Your Ref: 2026/90205

13th February 2026

Birkenshaw Liberal Club, 10 Croft Street, Birkenshaw - (KIRK) Discharge of details reserved by condition 20 (foul and surface water drainage strategy) on previous permission 2024/91853 for erection of 21 dwellings with garages, formation of adoptable road, private road and parking spaces and new car park and beer garden for the Liberal Club

DRAWING NUMBER: 48785 - ECE - XX - XX - DR - C - 0010 P05  
 Project Originator Zone Level Type Role Number

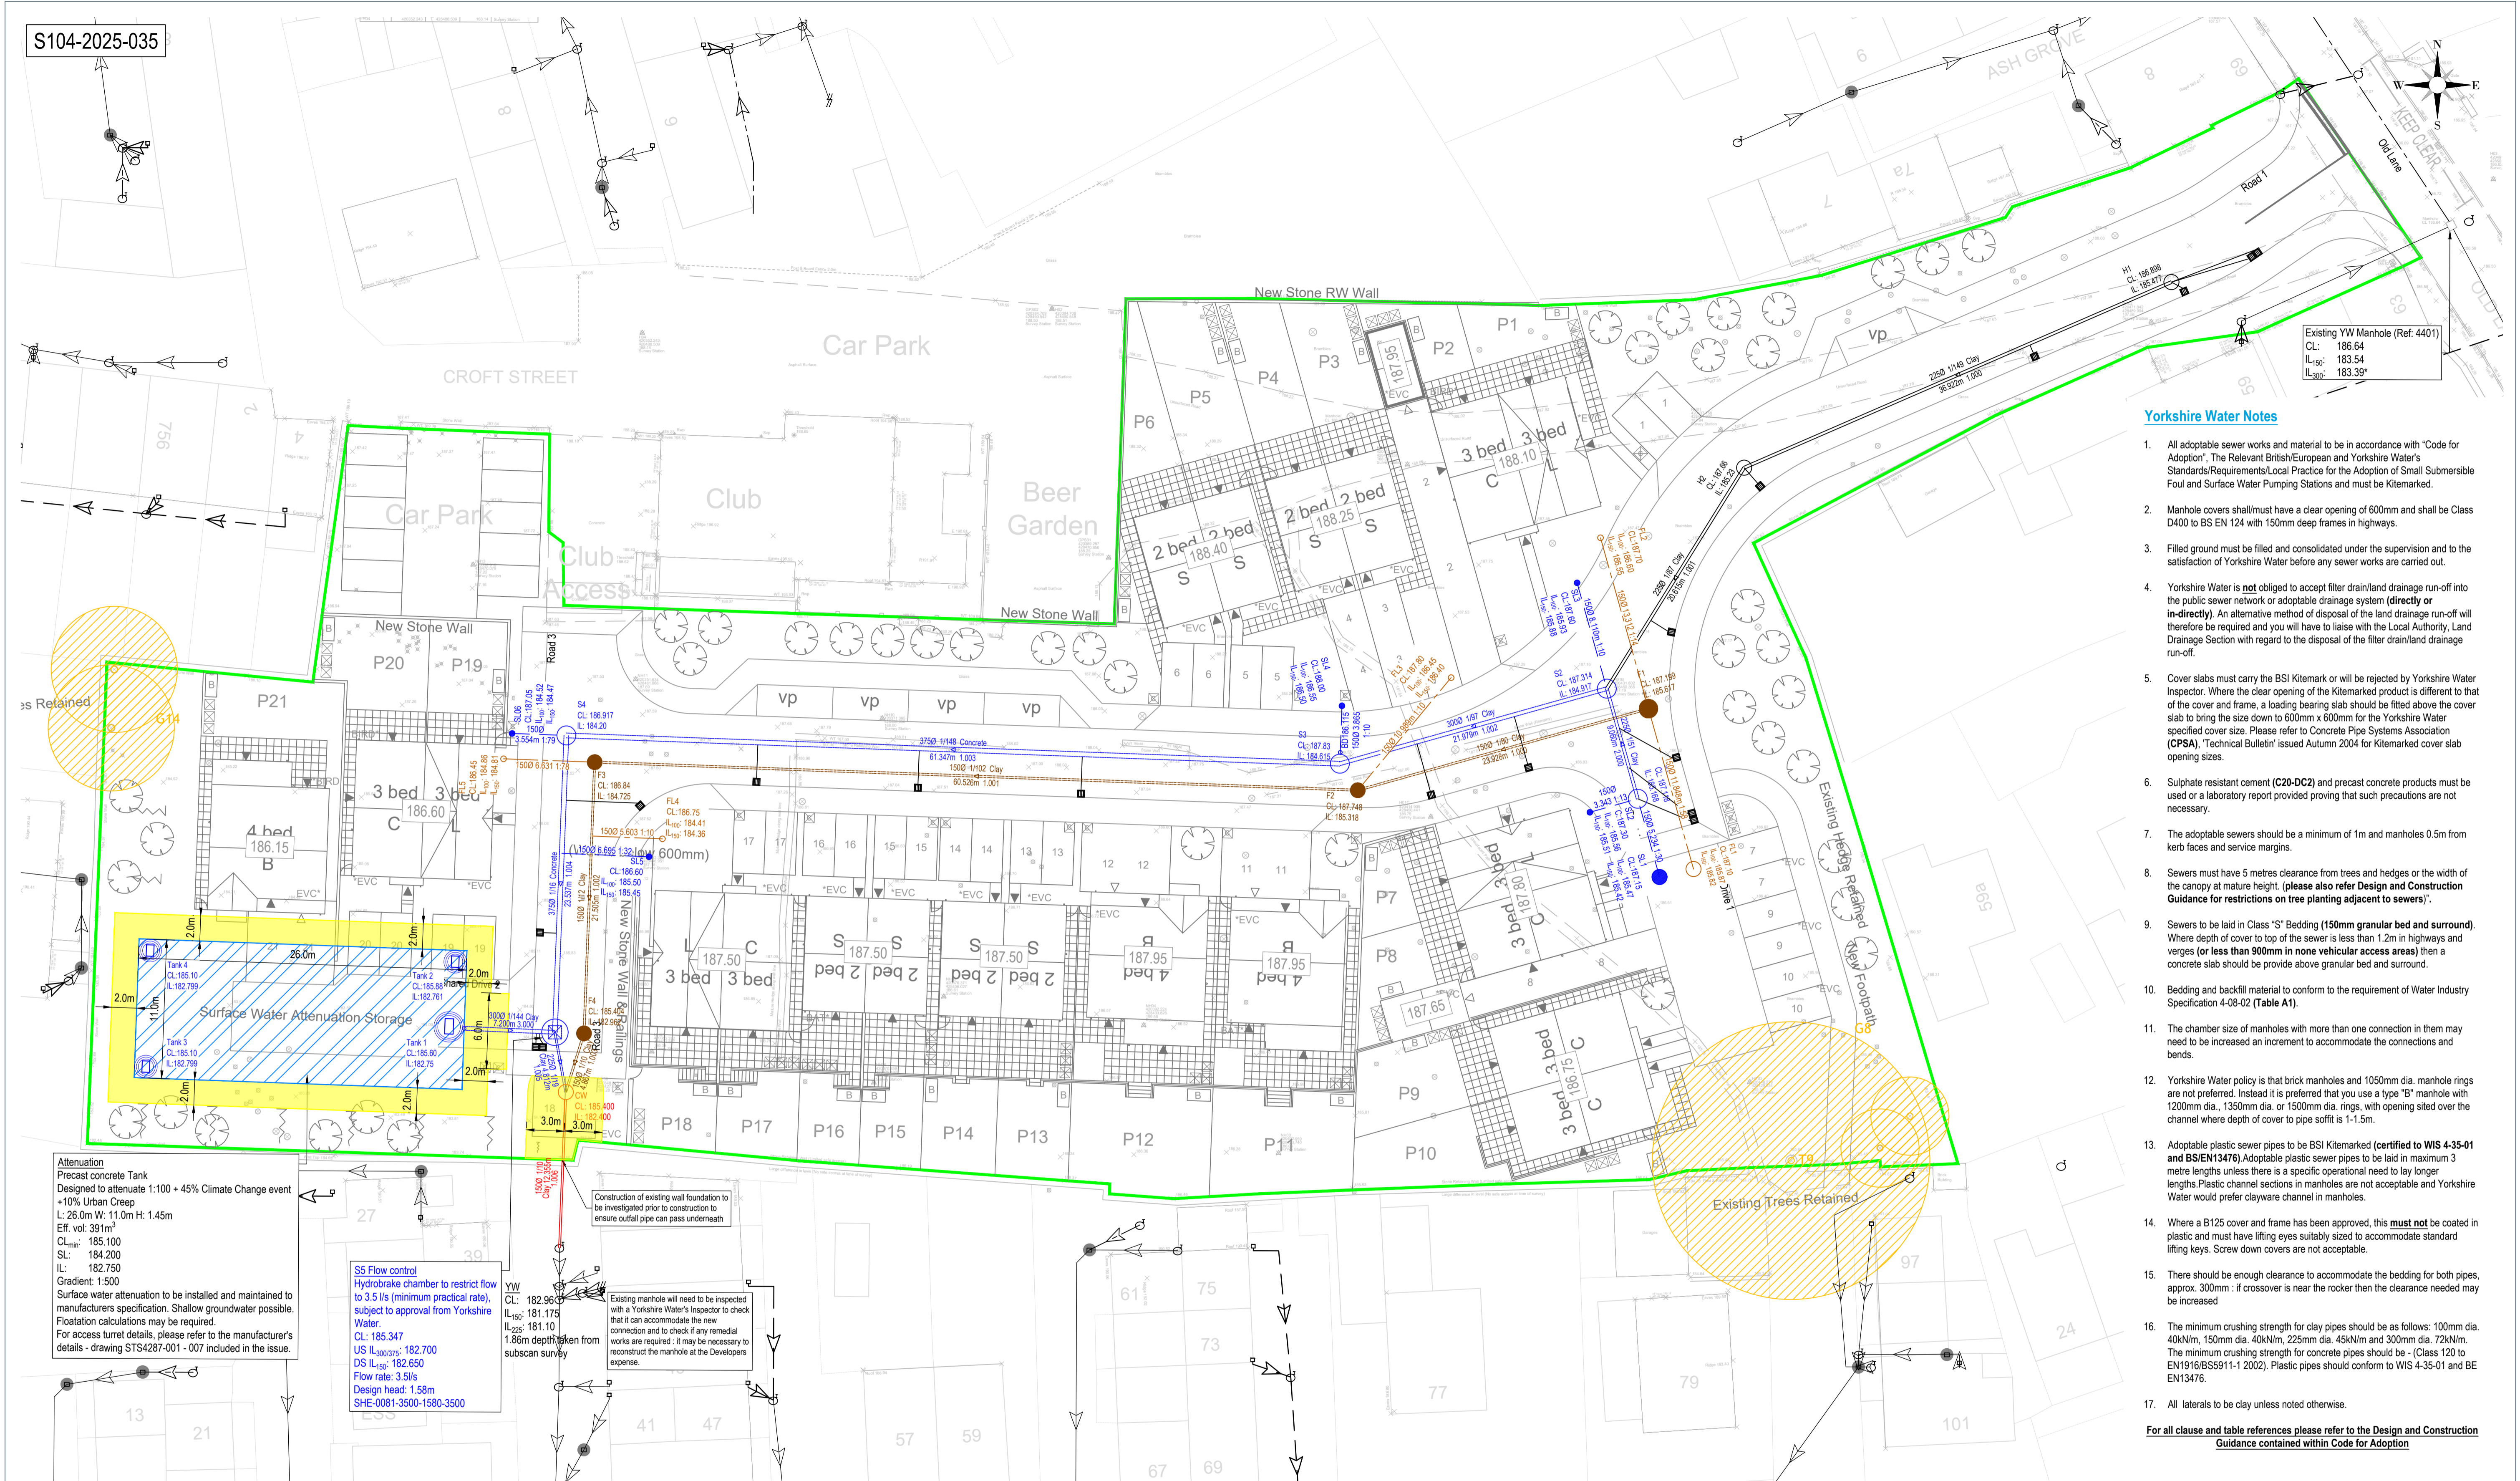
Yorkshire Water has no objection to the discharge of condition 20.

Yorkshire Water has no objection in principle to:

- 1) The proposed separate systems of drainage on site with combined off-site
- 2) The proposed amount of curtilage surface water to be discharged to the public combined sewer at a restricted rate of 3.5 (three point five) litres/second
- 3) The proposed point of discharge of foul and surface water to the public 225mm diameter combined sewer south of site

submitted on drawing 4875-ECE-XX-XX-DR-C-0010 (revision P05) dated 19/11/2025 that has been prepared by Eastwood Consulting Engineers.

The developer should also note that the site drainage details submitted have not been approved for the purposes of adoption or diversion. If the developer wishes to have the sewers included in a sewer adoption/diversion agreement with Yorkshire Water (under Sections 104 and 185 of the Water Industry Act 1991), they should contact our Developer Services Team (tel 0345 120 84 82, email: technical.sewerage@yorkshirewater.co.uk) at the earliest opportunity. Sewers intended for adoption and diversion should be designed and constructed in accordance with the WRc publication 'Sewers for Adoption - a design and construction guide for developers' 6th Edition, as supplemented by Yorkshire Water's requirements.
